Consultation Response from KC, Conservation & Design**2023/92490 Former Dowker Works, Dowker Street, Milnsbridge, Huddersfield, HD3 4JX****Erection of 38 dwellings with associated access and landscaping (within a Conservation Area)****Date Responded: 13.10.2023****Responding Officer: Sue Brooks****Responding Ref:**

DESCRIPTION:
Street Elevations 2/2

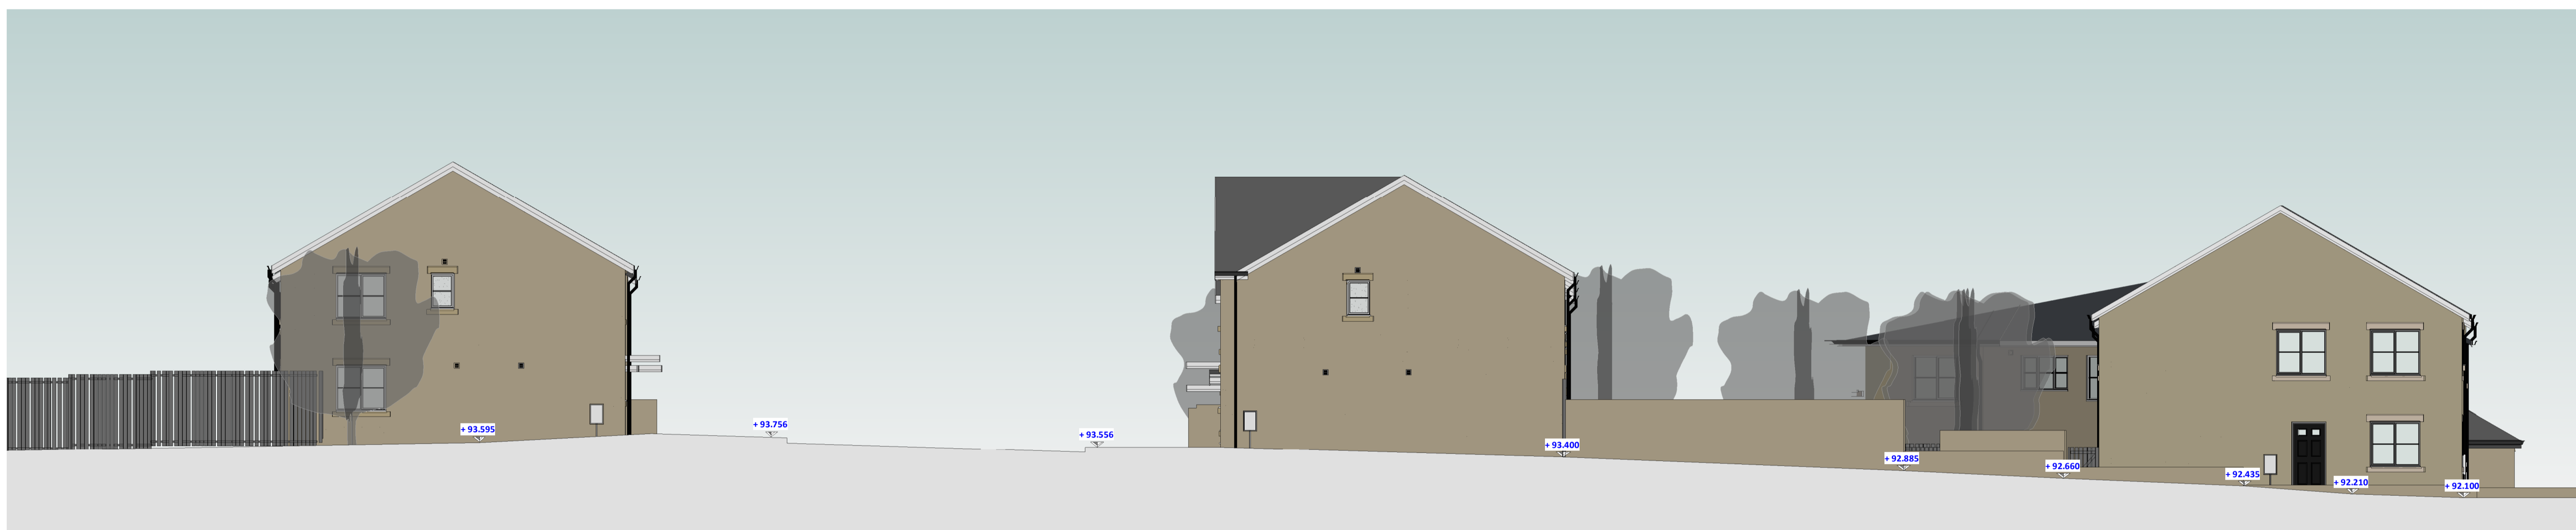
- Air Source Heat Pumps – details, size and locations have not been submitted and should be located on rear elevations.
- Plots 27-28 is particularly concerning as this has a long blank south elevation which will be seen directly in context with the listed hall, and we feel that the layout needs to be more carefully considered to create more interest. To reflect the character of the surrounding terraces and reduce the number of doorways in these elevations, two-storey dwellings may be a more suitable option in this setting. A street scene should also be provided for George Street as this is not represented in the submission pack and we have concerns in respect of its appearance.

DESCRIPTION:  
Cottage Flats Type 1 Elevations

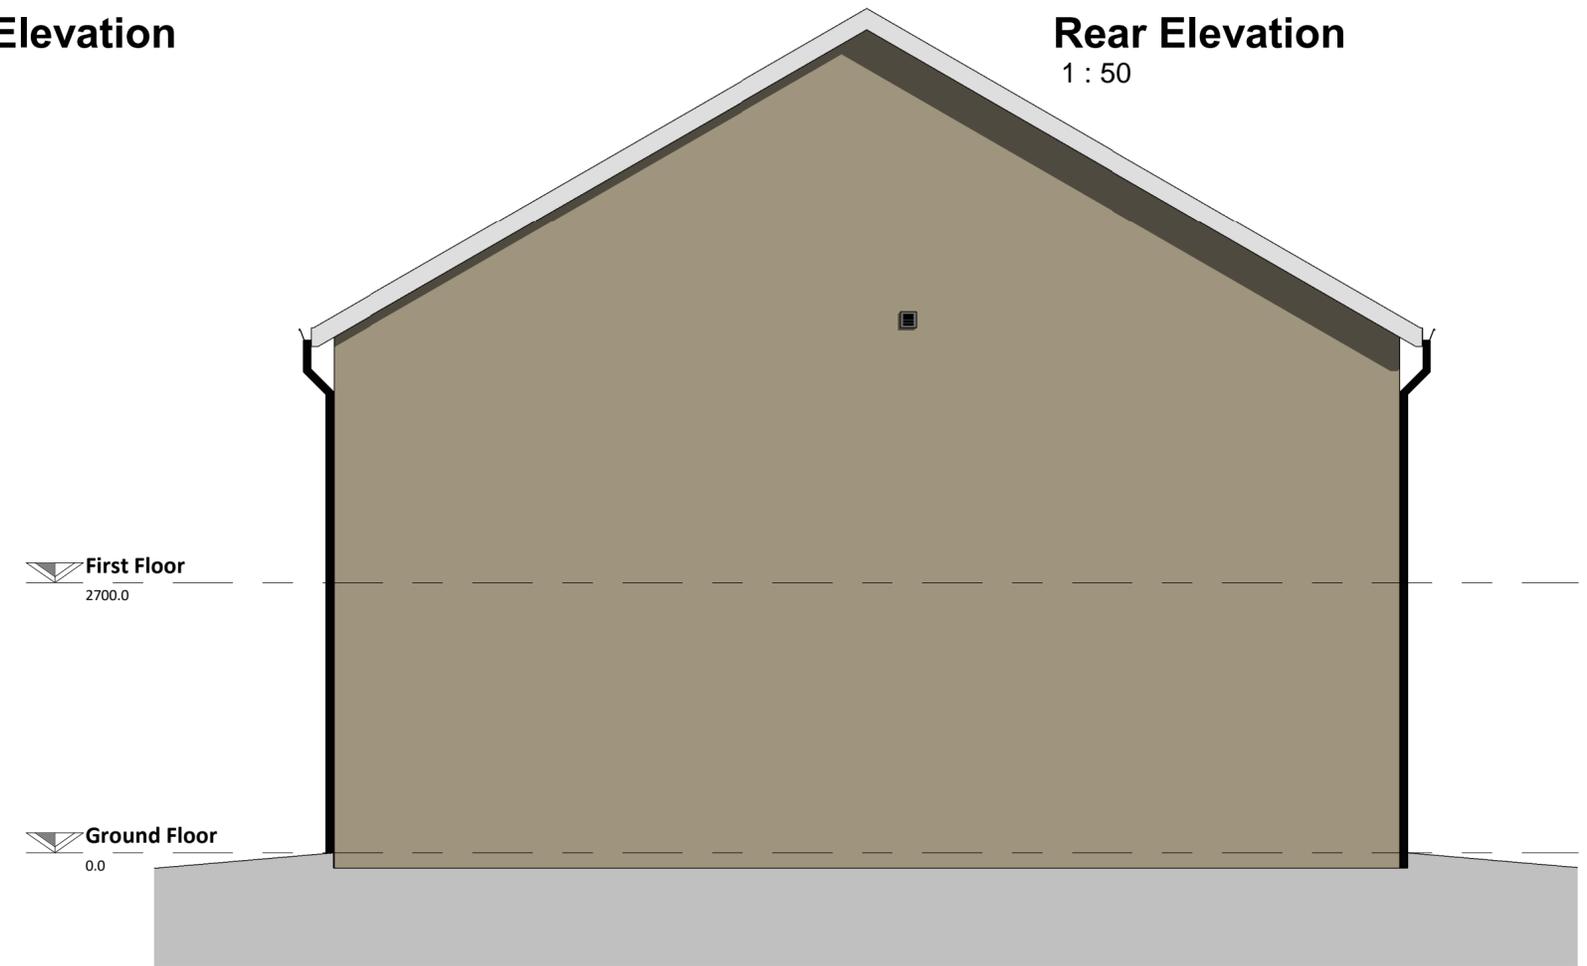
- Rather than the proposed windows which have a horizontal emphasis, we would suggest that windows on the front elevations have a vertical emphasis and one over one with a sash type configuration. This would be more typical of the terraced housing within the conservation area and immediate setting. We would also suggest panelled doors which reflect the character of the 19th century terraces.

- Again, to reflect the local character, stone gutter corbels would be more in keeping than the uPVC fascias as specified.
